**Subject:** RE: Resort of the Future, Butlins Bognor Regis - URGENT (BR/234/21/PL)

Please accept this email as a formal consultation response.

After review of the submitted documents and latest information presented by the applicants, the Local Highways Authority is satisfied that the proposed rear extension will better facilitate exiting operations on site and will not generate any additional trips to the Butlins site, as such it would not be anticipated that the proposed will result in an unacceptable impact on highway safety or result in 'severe' cumulative impacts on the operation of the highway network, therefore is not contrary to the National Planning Policy Framework (paragraph 111), and that there are no transport grounds to resist the proposal.

Drawn: JD Approved: JULY 2021
Scale: 1:200 @ A1 PRINT SIZE
Sheet Description:
SITE LAYOUT PLAN
Sheet Number: IPL_21_363/12_101 Issue: 06-LPA

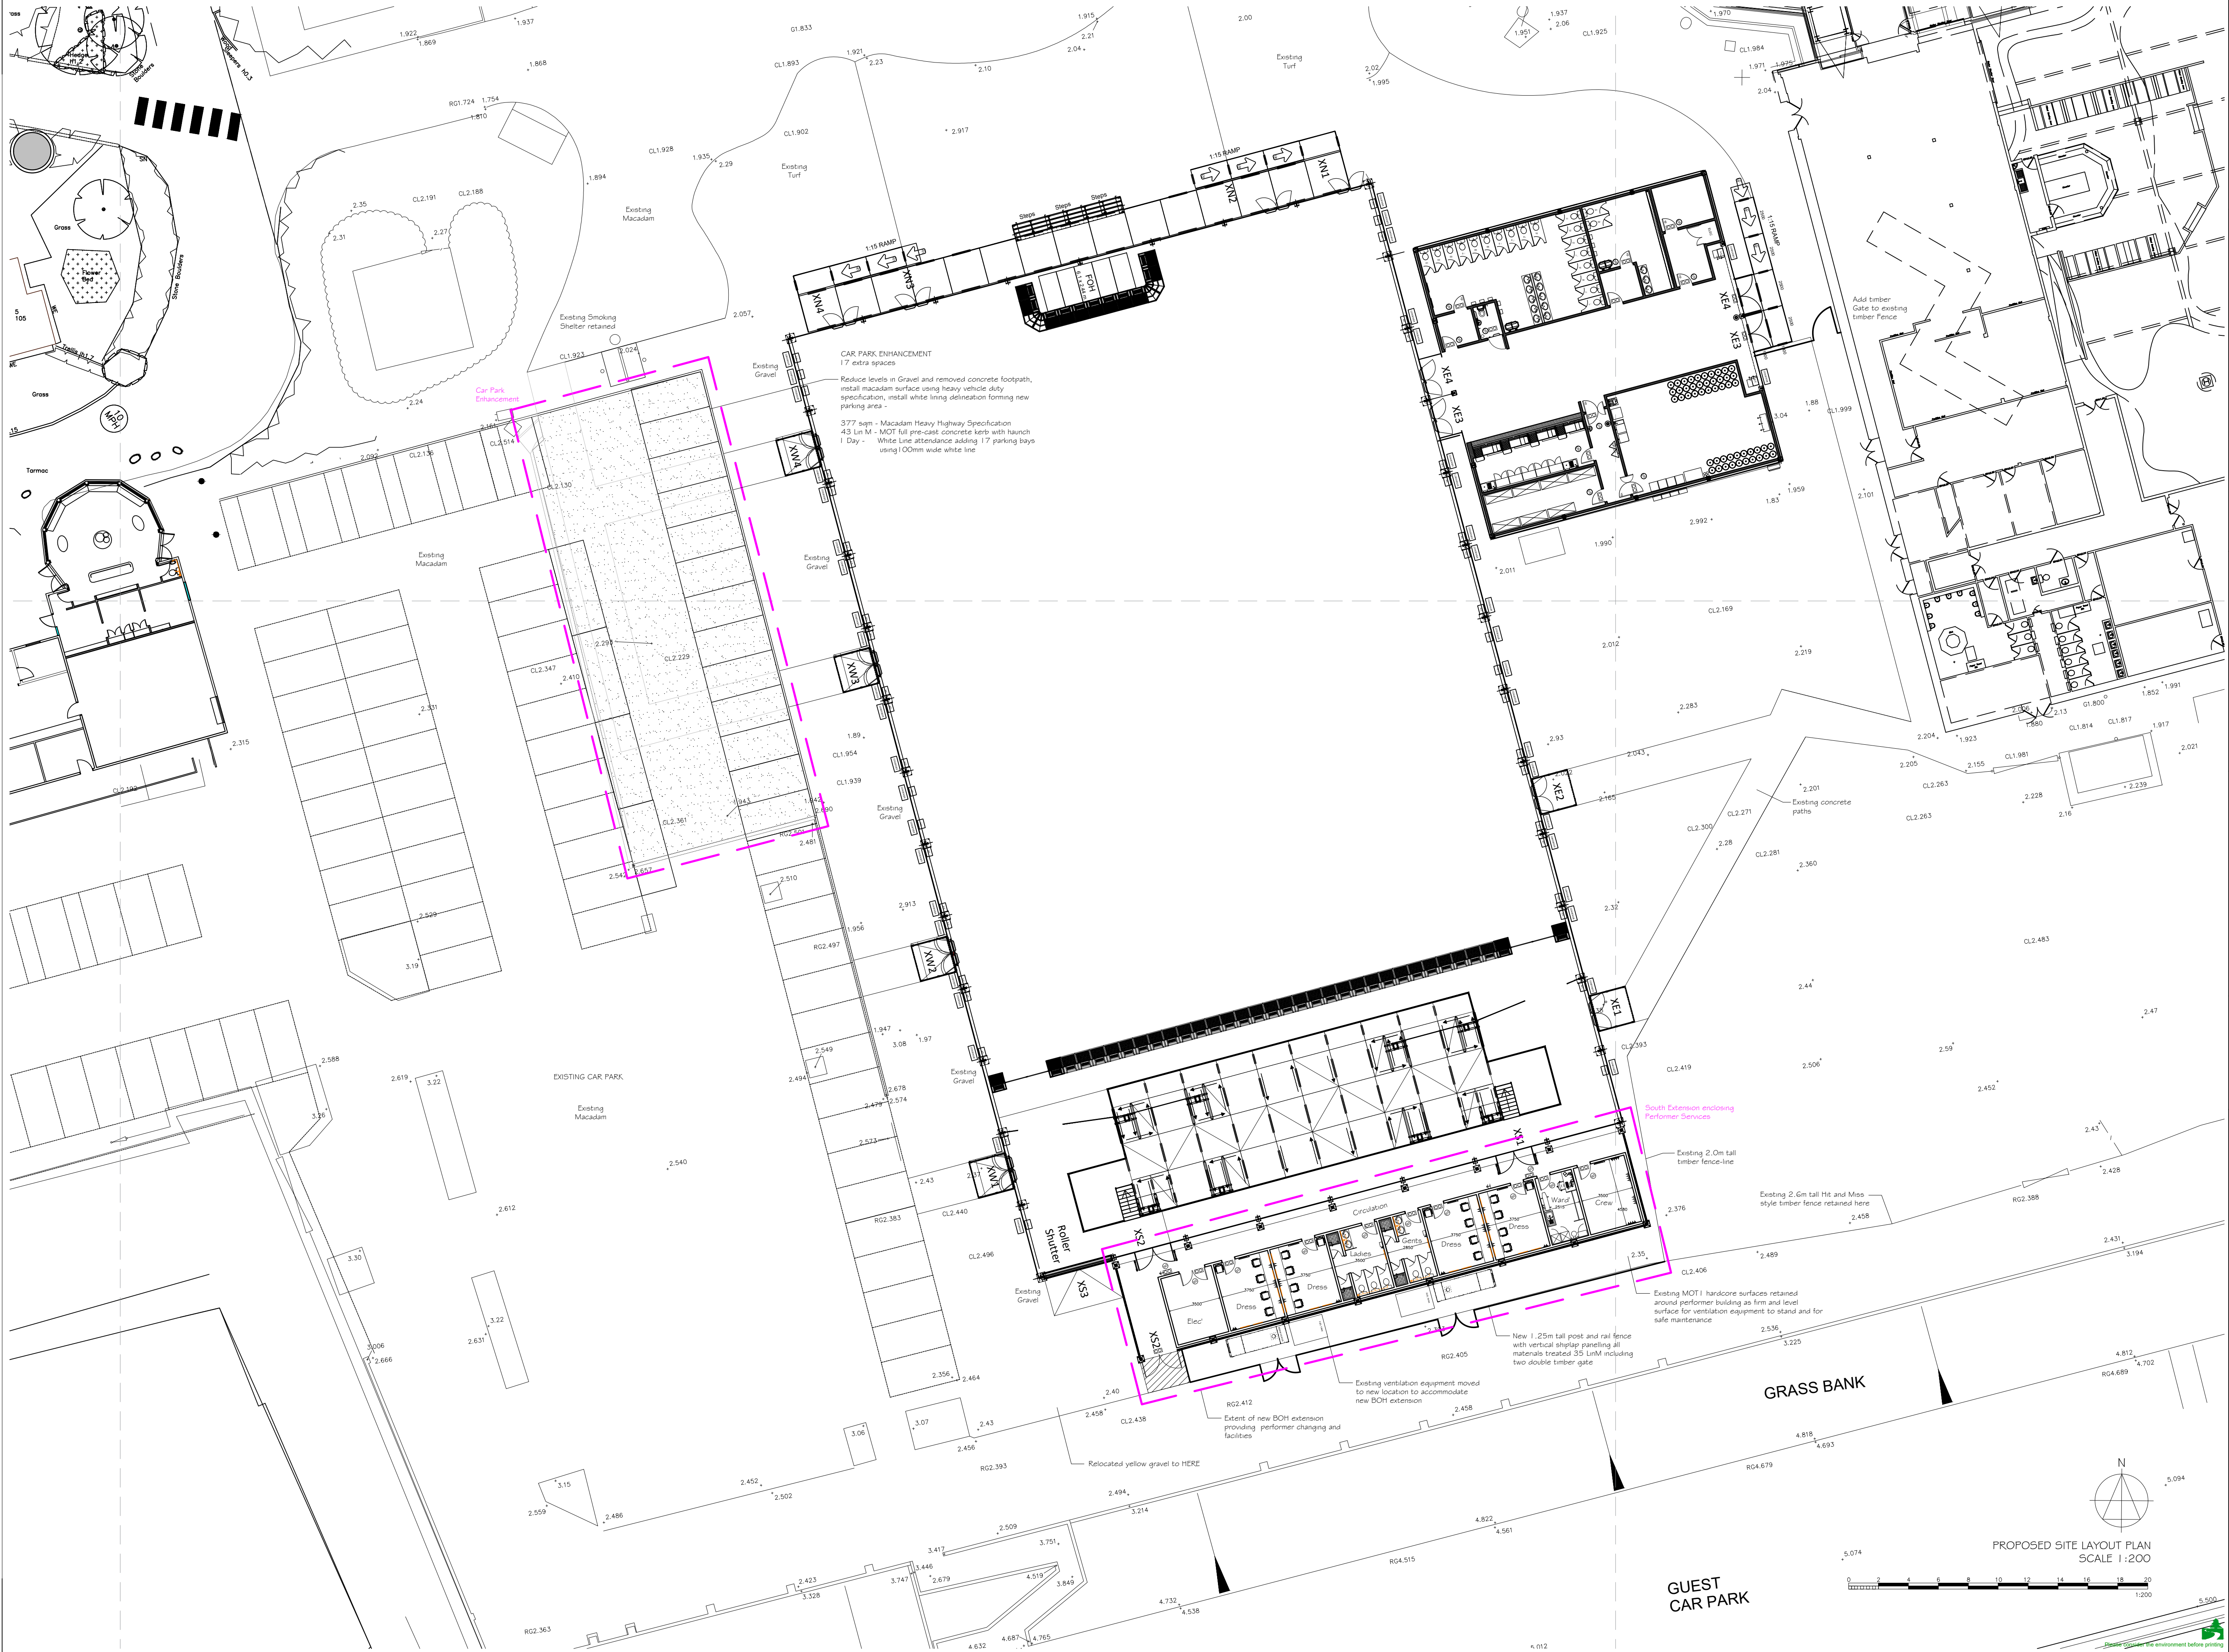
It is understood that the car park works are required to improve upon and increase parking provision on site by 17 spaces (4 parallel spaces, 13 perpendicular). From inspection of this plan the spaces are suitably sized. It is noted that the manoeuvring room between the perpendicular and parallel spaces is 5.5 metres. It is widely accepted within Manual for Streets Guidance that 6.0 metres manoeuvring room is required to access perpendicular spaces in one movement. Based on the plans provided it would be anticipated that these new perpendicular spaces would need to be accessed via a multi-point manoeuvre, which is considered acceptable in slow speed low flow situations such as in car parks like this. The applicant may wish to consider removing the 4 parallel spaces to improve accessibility of the perpendicular spaces, but this would be for the benefit of amenity rather than anything related to highway safety.
